From: Anna Gillings <[REDACTED]>
Sent: 16 July 2018 10:58
To: Juan Baeza
Cc: Timothy Bloomfield; Sam Rous; Emma Patchell
Subject: RE: A/23/18/DOC - Broadlees, Dappers Lane, Angmering

TREE PROTECTION (Plan 3A)

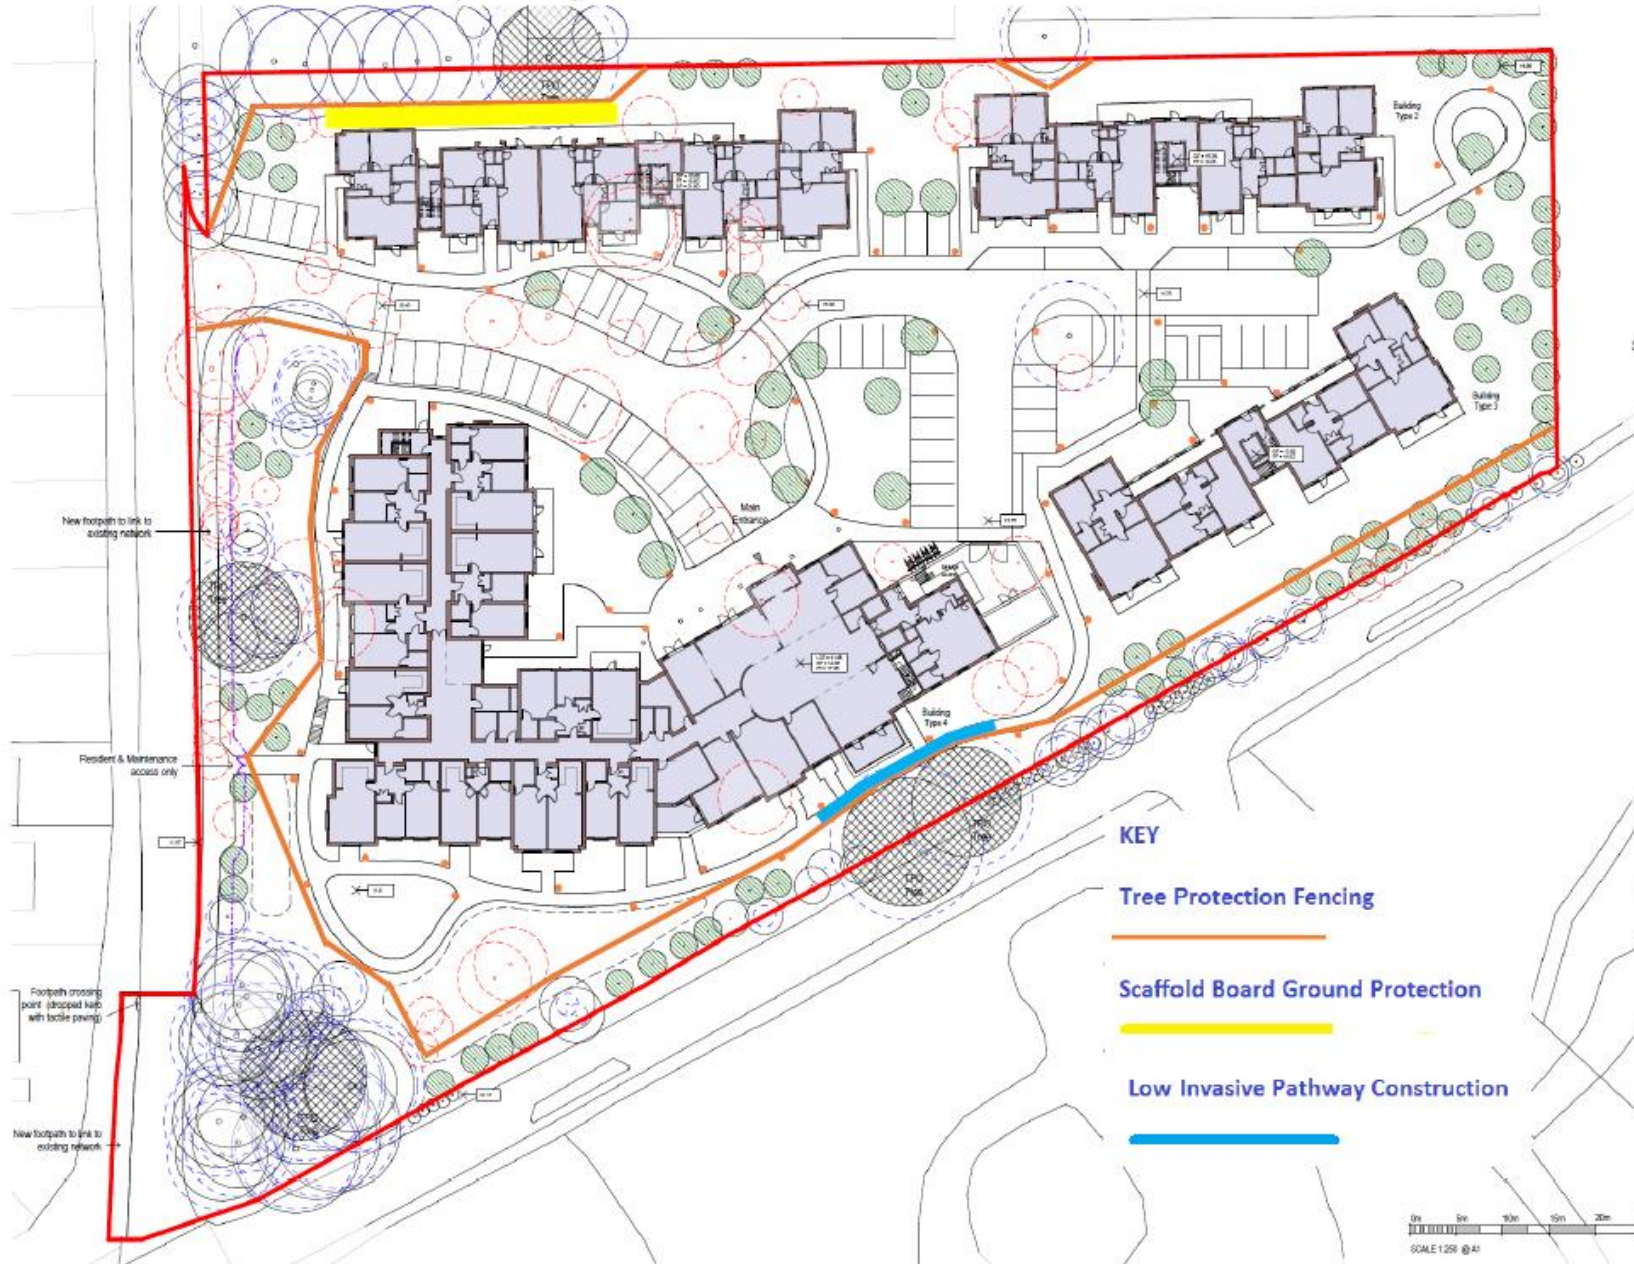
Any tree protection measures must be in place before heavy plant access, soil movement, demolition or construction occurs. The prior installation of an effective 'Construction Exclusion Zone' and any specified ground protection measures must be inspected by and be to the satisfaction of the LPA (Tree Officer) before the appropriate condition can be discharged. Anything less and we are facilitating the occurrence of potentially irreversible damage to those trees identified for retention.

I note that the applicant has submitted a Tree Protection Plan Ref: Plan 3A – the measures set out on this plan are acceptable but will need to be implemented and then a Pre-Commencement Meeting can take place [at a mutually convenient time] between the applicants representative and the Arun DC Tree Officer to agree that the Protective Fencing complies with BS5837 recommendations and is 'Fit For Purpose' and that it has been erected exactly as shown on Plan 3A".
